RE: Planning Application No.3/2021/011

Please take into consideration the following objections regarding the above planning application for the proposed dwelling on George Lane. We do feel that the following points need to be addressed before the planning application is accepted.

Representations (object) to planning application ref: 3/2021/0011 in respect of land adjacent to 34 and 40 George Lane, Read for the following reasons:

sheet: garage plan and elevation

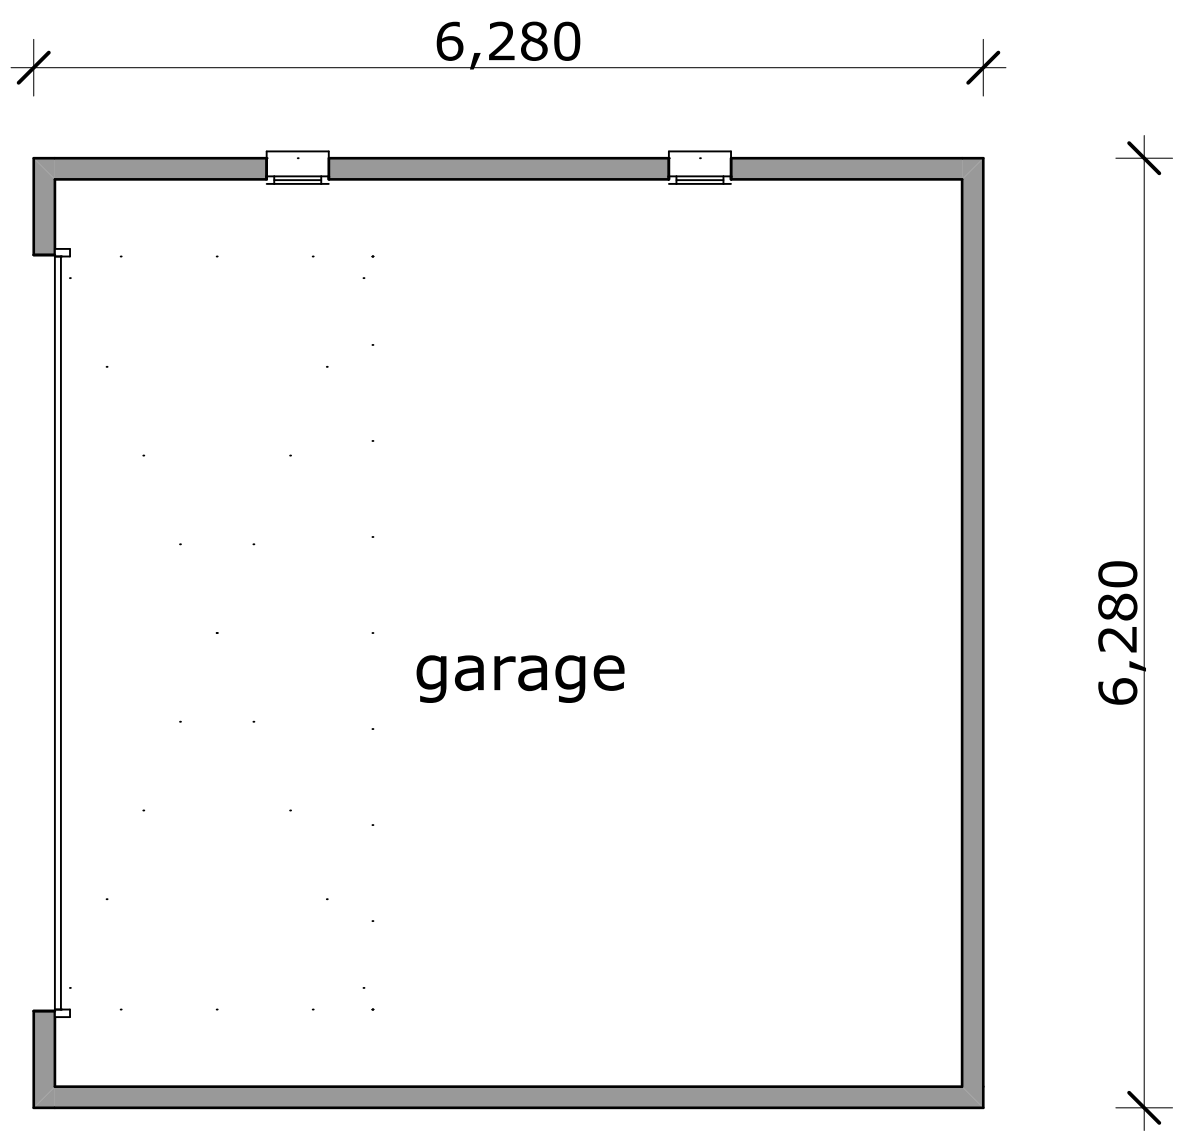
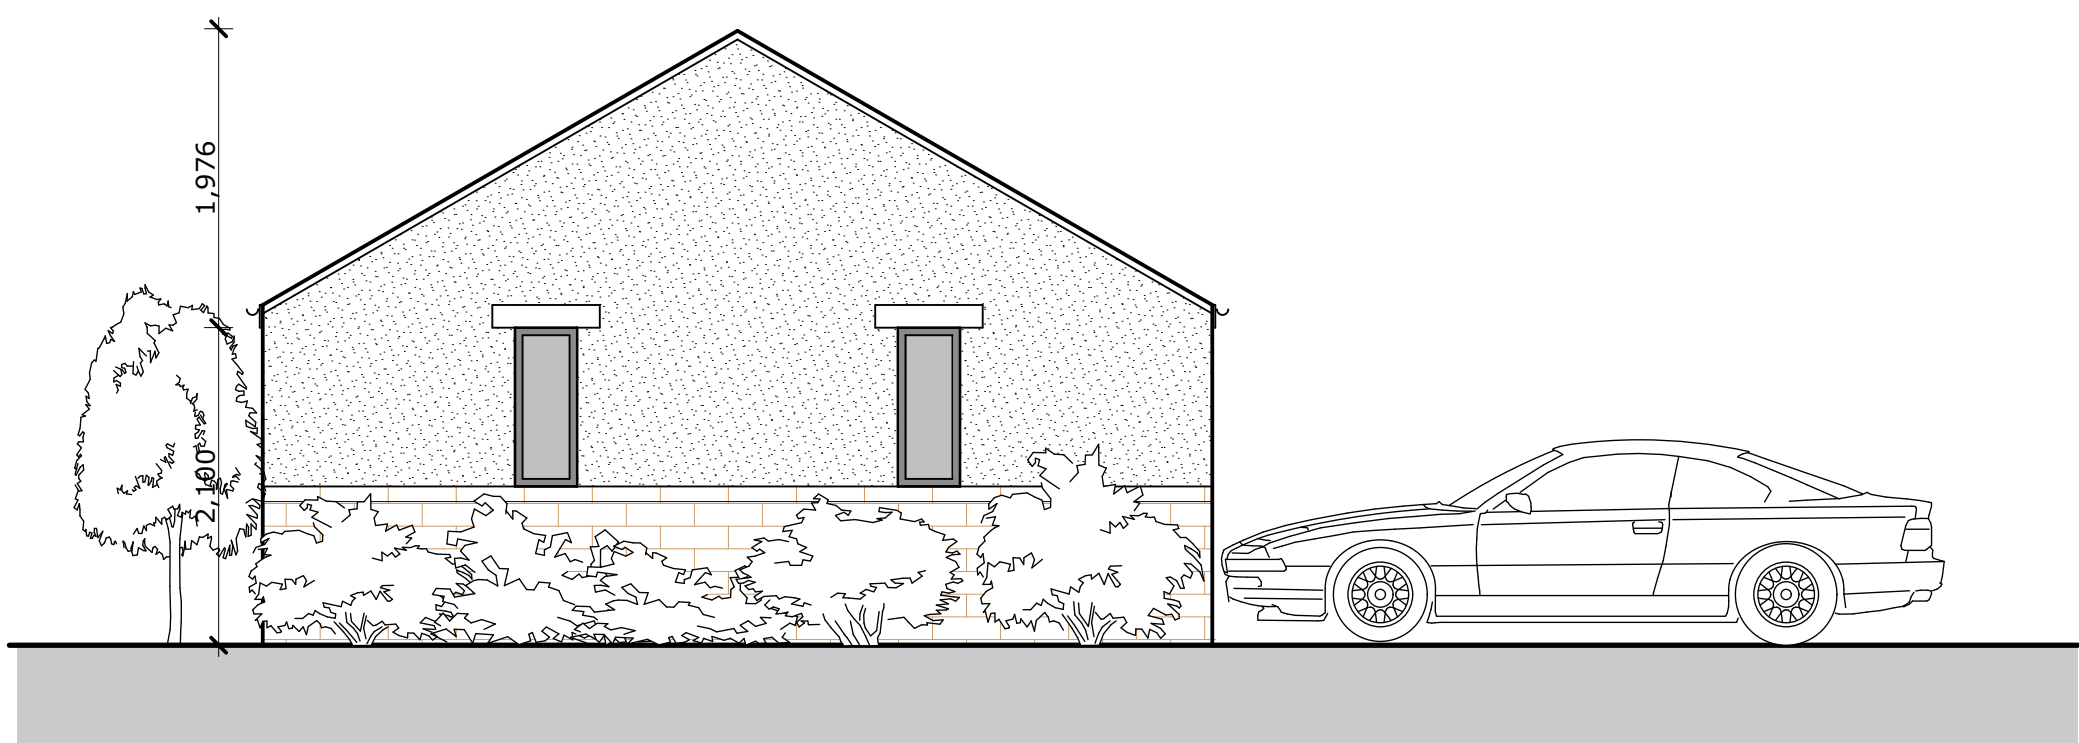
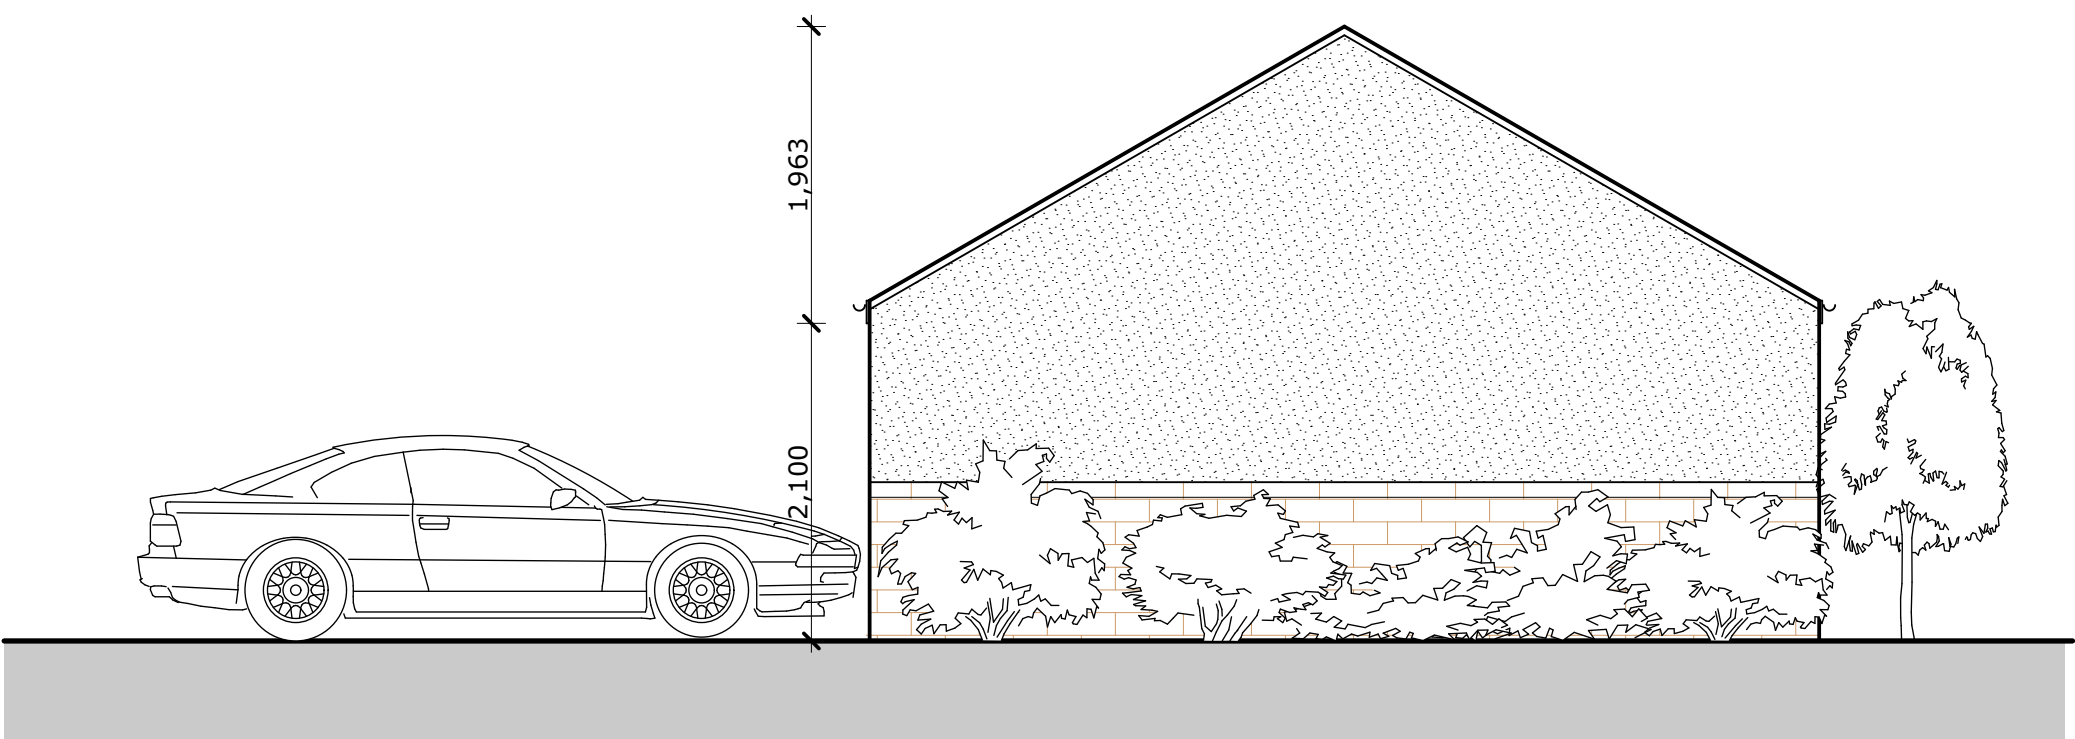
- The original outline plan permits the construction of a single dwelling and does not consent to the construction of a detached double garage as is now proposed. The newly proposed double garage will be situated very close to the roadside and isn't in keeping with the other houses adjacent to the development and further up George Lane as these all have open fronts.

3. The outline consent permits the construction of one new dwelling and does not consent to the construction of a detached double garage as is now proposed. The proposed location of the double garage at the front of the dwelling and adjacent to George Lane is inappropriate and is not in keeping with the surrounding properties on the upper part of George Lane, all of which have open frontages/gardens with buildings being set well set back from the road. The form and scale of development proposed and its relationship with the existing dwellings on George Lane is one which represents an overbearing and generally un-neighbourly form of development with likely adverse visual impact and overbearing presence leading to loss of amenity. See also comments above regarding Policy DMG2 of the Core Strategy.

sheet: os plan

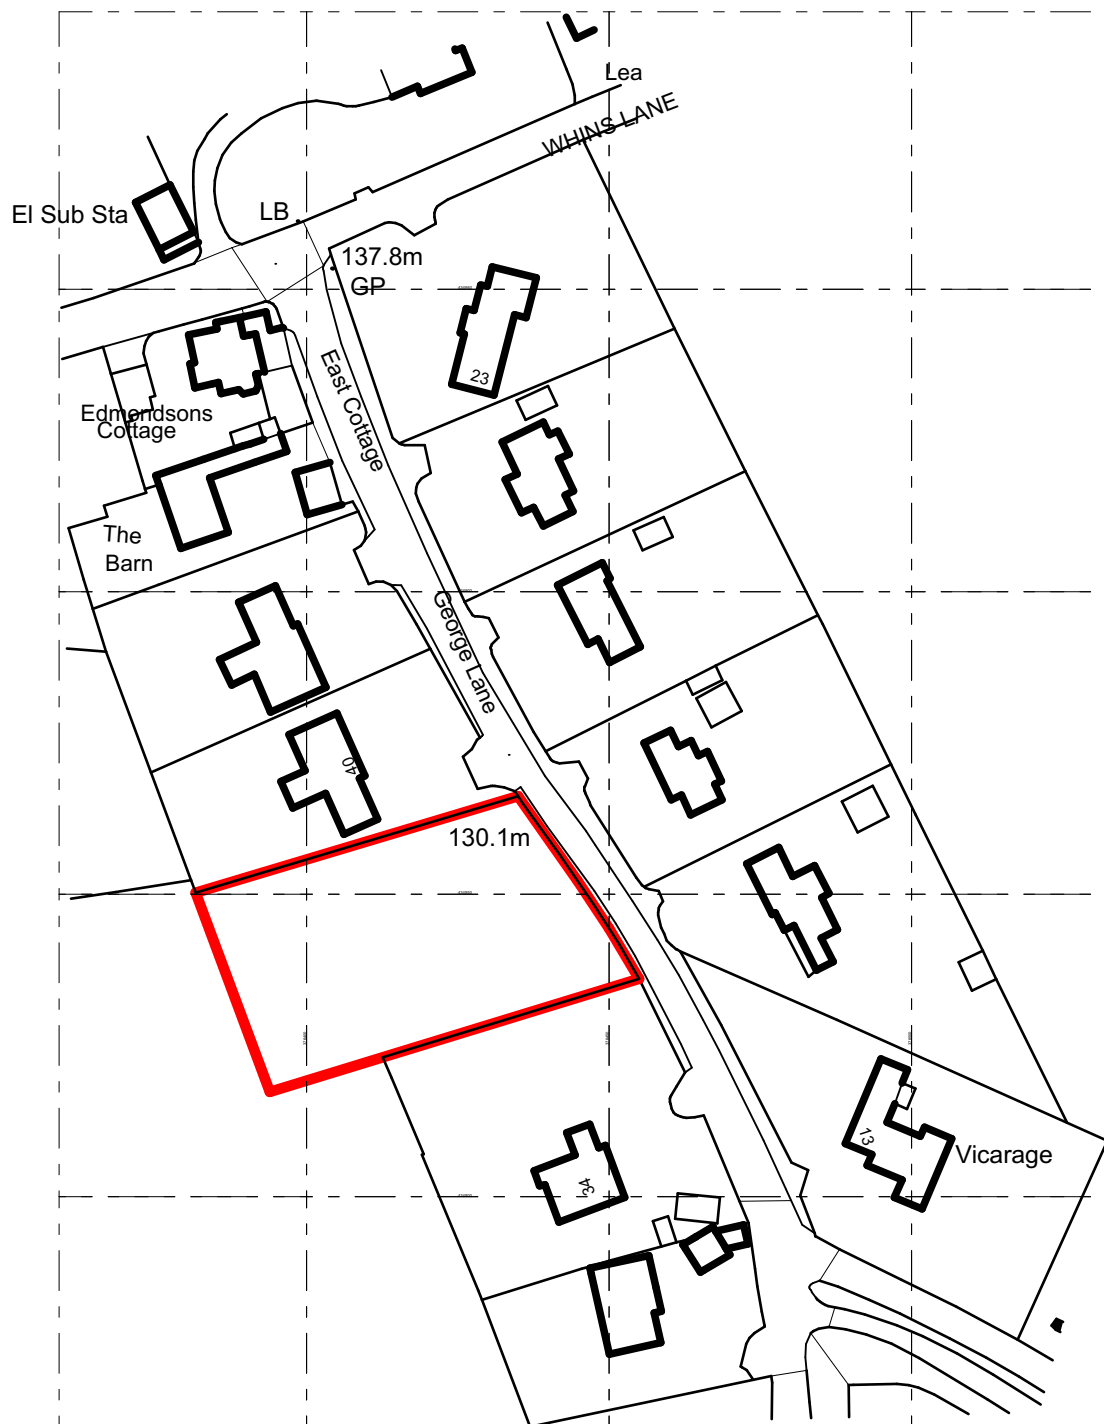
- The plot on this plan extends well into Hammond Ground and is significantly larger than the approved site layout plan on the original outline application which was in line with other properties on George Lane. The situation of the original property also differs from the original application in that it is much larger and nearer the road than the neighbouring properties of 40 and 42. This means that the landscape and visual amenity will not be in keeping with the other properties on George Lane. Being closer to the road will also impede on our privacy as it will look directly on to us.

1. The outline consent permits development substantially in accordance with the (revised) location plan and site layout plans i.e.
1103-05 A - Location Plan (received 15/01/2020)
1103-02 B - Site Layout Plan (received 15/01/2020).

The application for detailed consent relates to a larger area and is not as shown on the approved site layout plan but instead reflects the original site layout plan which was submitted with the outline application. This was revised following representations from the adjoining owners regarding the extent of the site and in particular the line of the western boundary. The site now extends into the Hammond Ground site (which as evidenced by earlier planning refusals is not considered suitable for development) and thus the proposed development would impinge upon the historic parkland of Read Hall.
